**RE: Request for Further Information
Lingard Private Hospital Expansion (SSD-60316710)**

This letter is submitted to the Department of Department of Planning, Housing and Infrastructure in response to the Request for Further Information (RFI) issued on 10 December 2024, relating to SSD-60316710 for the proposed expansion of the Lingard Private Hospital.

1 21 JUNE 9AM - EXISTING
DA-201 Scale 1:500

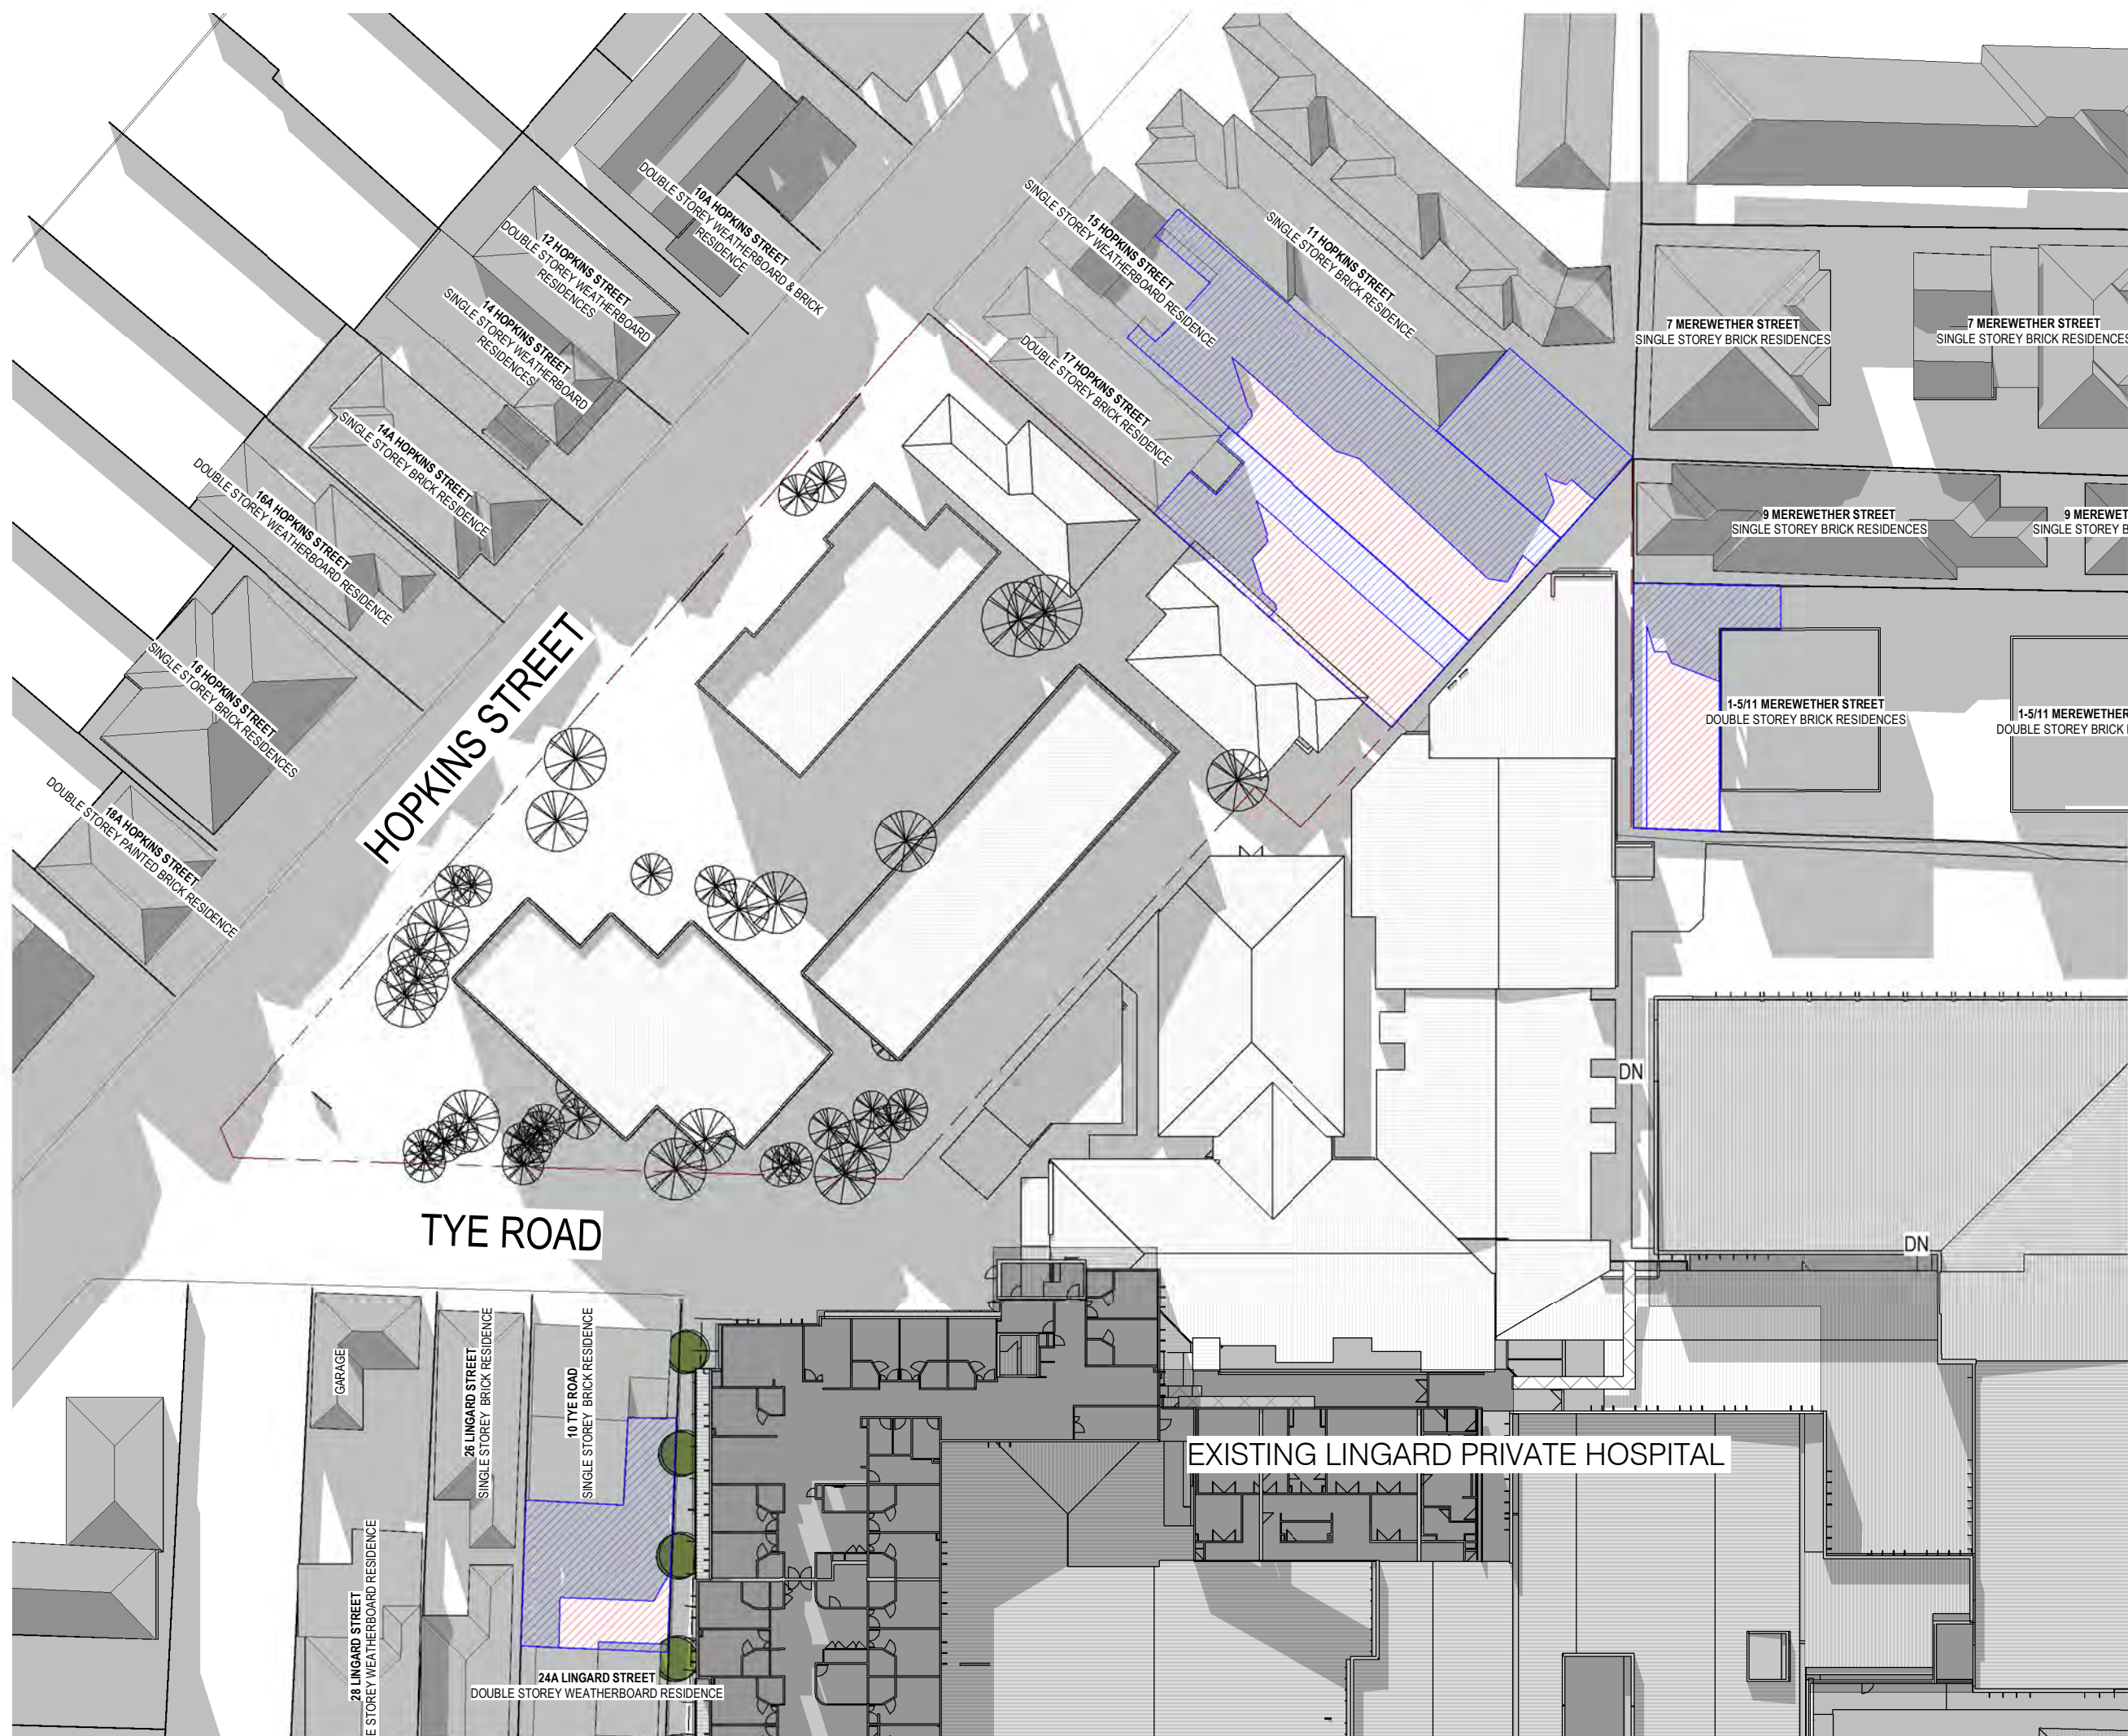
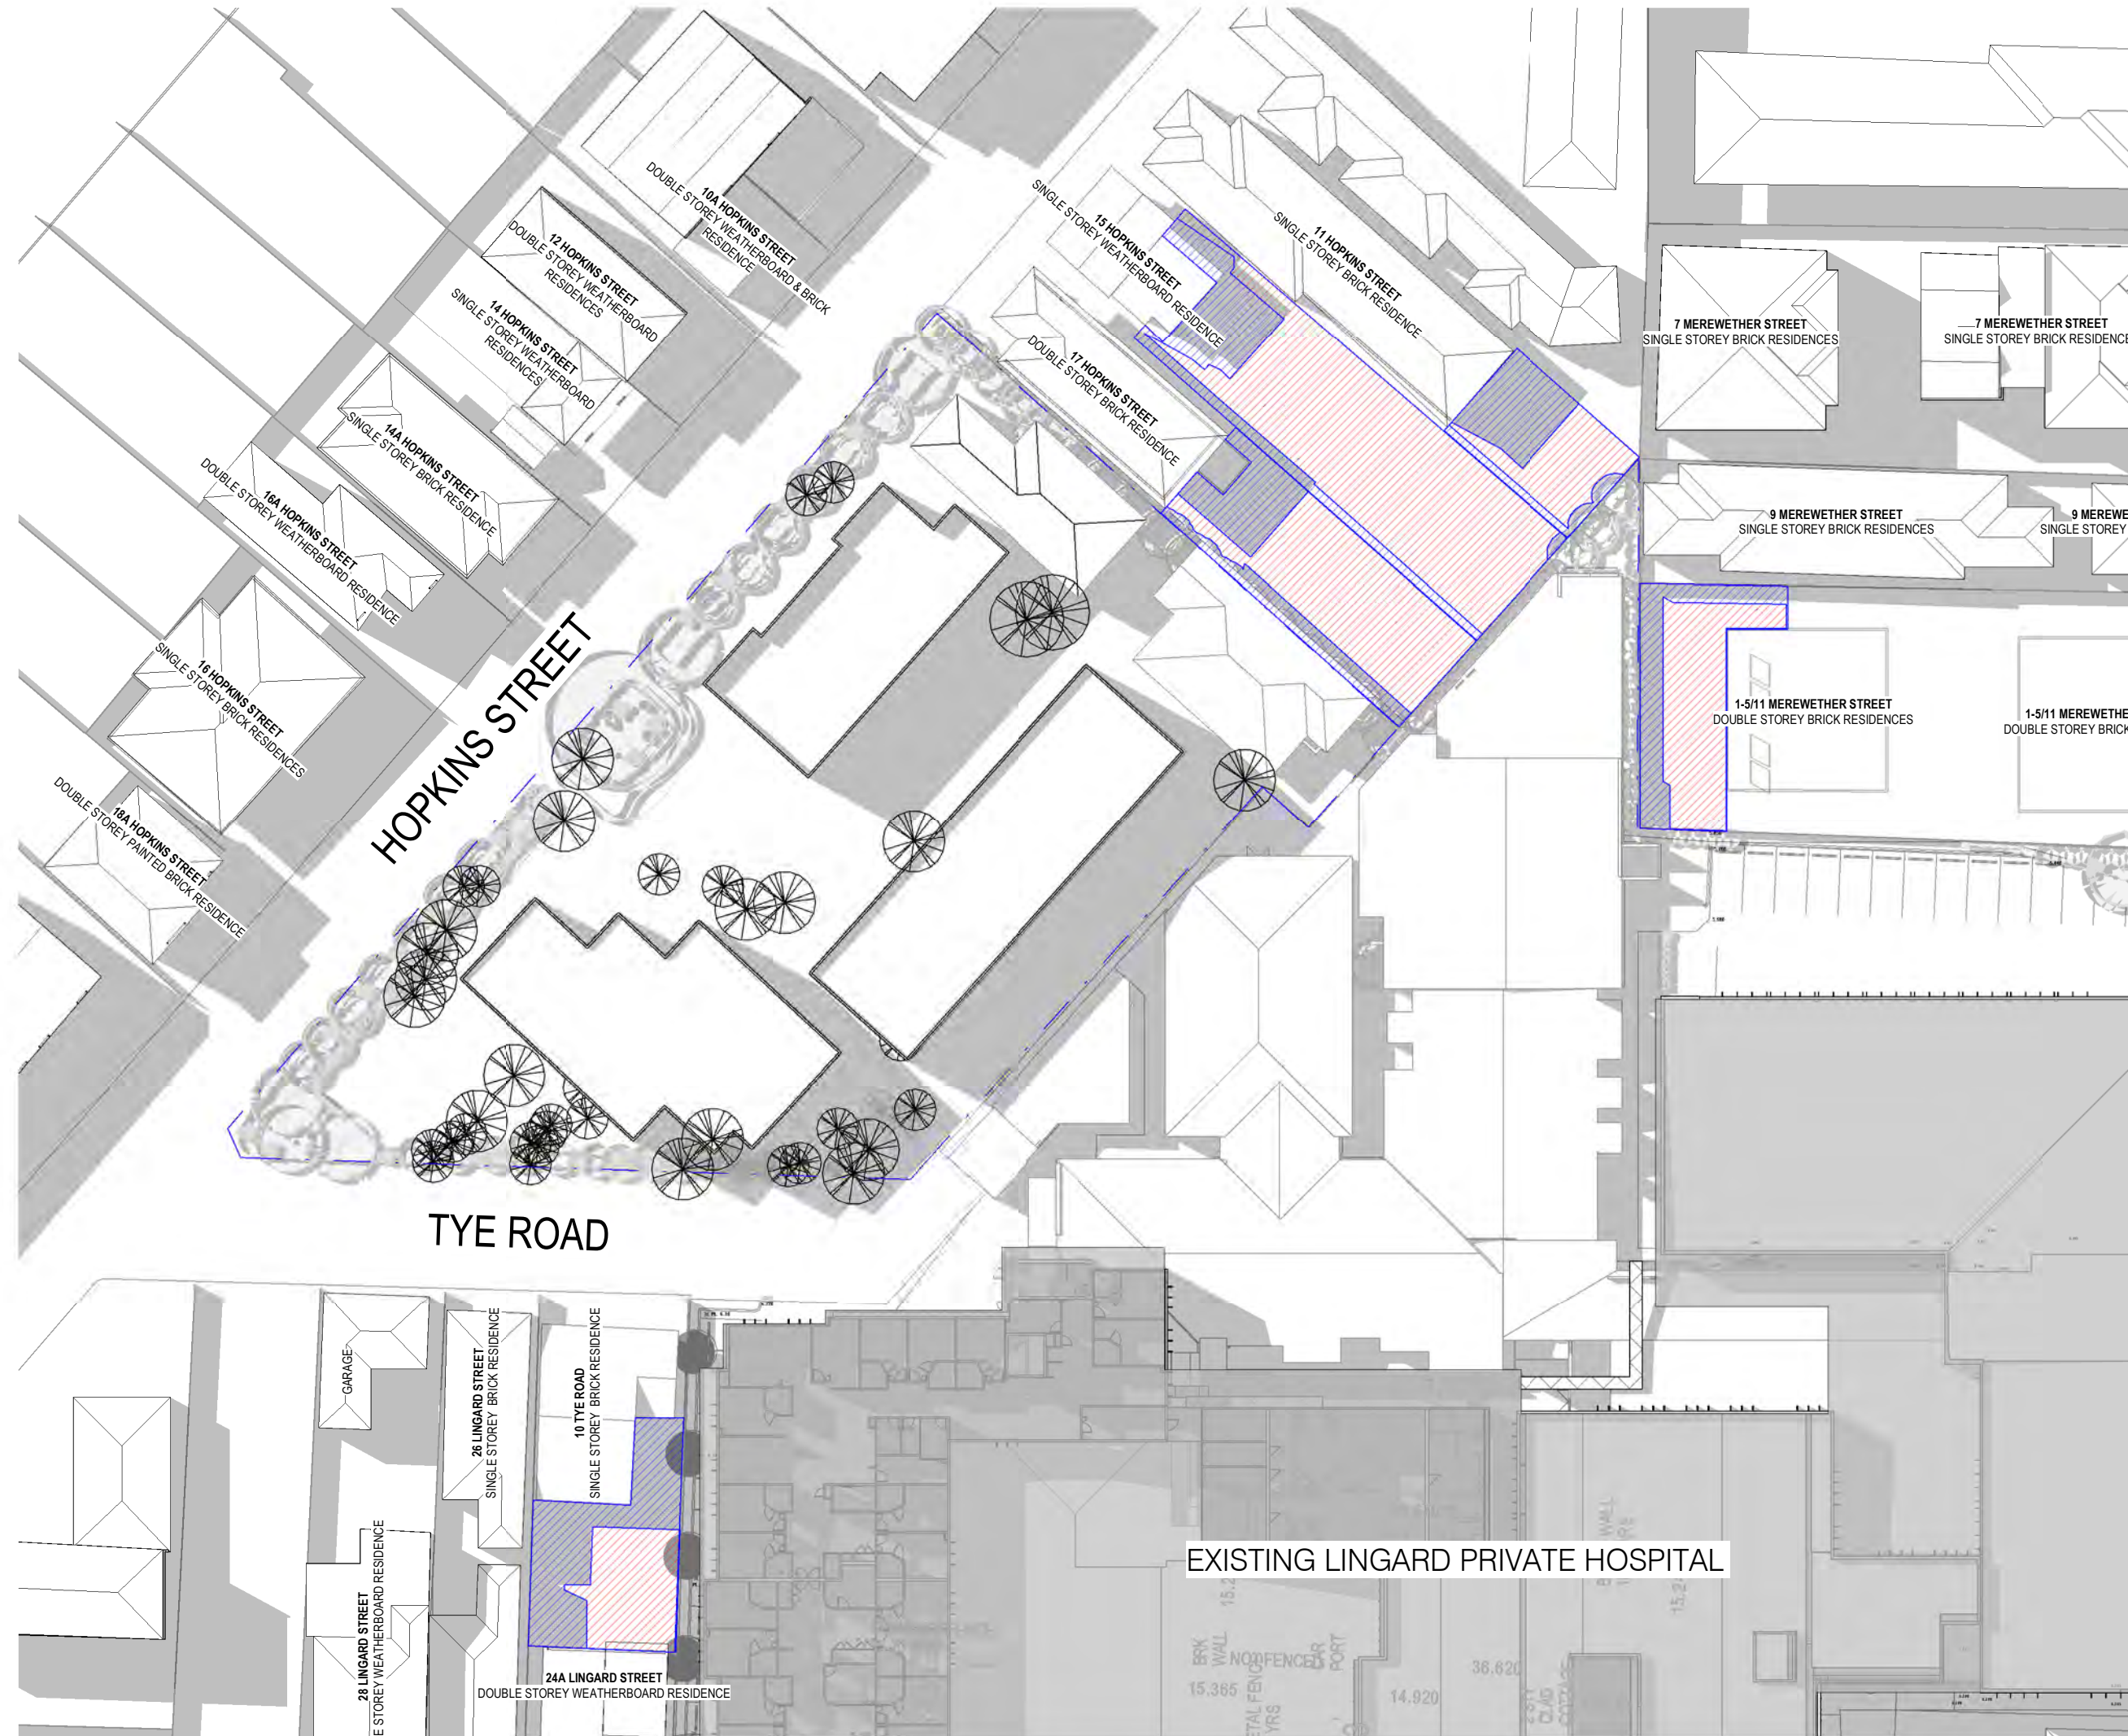
CN's concerns regarding residential amenity remain. The amended architectural plans do not include hourly shadow diagrams or 3D shadow analysis to identify the habitable rooms and private open space of residential properties, as previously requested. The shadow impact to Mitchell Park has not been adequately addressed.

The non-compliant height coupled with reduced setbacks on the eastern boundary of the Hopkins Precinct, exacerbate the amenity impacts. CN recommends the design is amended to reduce the bulk and ensure upper floor levels comply with the setback requirements and maximum building height development standard. CN recommends the applicant is required to submit additional shadow diagrams at hour intervals between 9am and 3pm during the June 21 winter solstice.

Additional shadow diagrams have been provided at Appendix A. The overshadowing of Mitchell Park is minimal, occurring only at 9 AM during winter. The affected area consists of large trees and on-street parking that would naturally be in shadow. The proposal ensures ample daylight reaches the trees and surrounding area at all other times.

The amended shadow diagrams include percentage calculations for the surrounding residential dwellings and confirm compliance. The most significant impact is on 11 Merewether Street in the afternoon; however, the existing shadow diagrams show that this is also the present state, refer to Figure 1 & 2 below. In the previous iteration of plans the second level wall was also setback further from this boundary.

The proposal does affect the adjoining Hopkins Street dwellings at 3 PM; however, there is no impact during the morning hours. The proposed setbacks are consistent with the existing dwelling setbacks in the area. While there is some overshadowing in the afternoon, the dwellings receive sufficient sunlight in the morning,
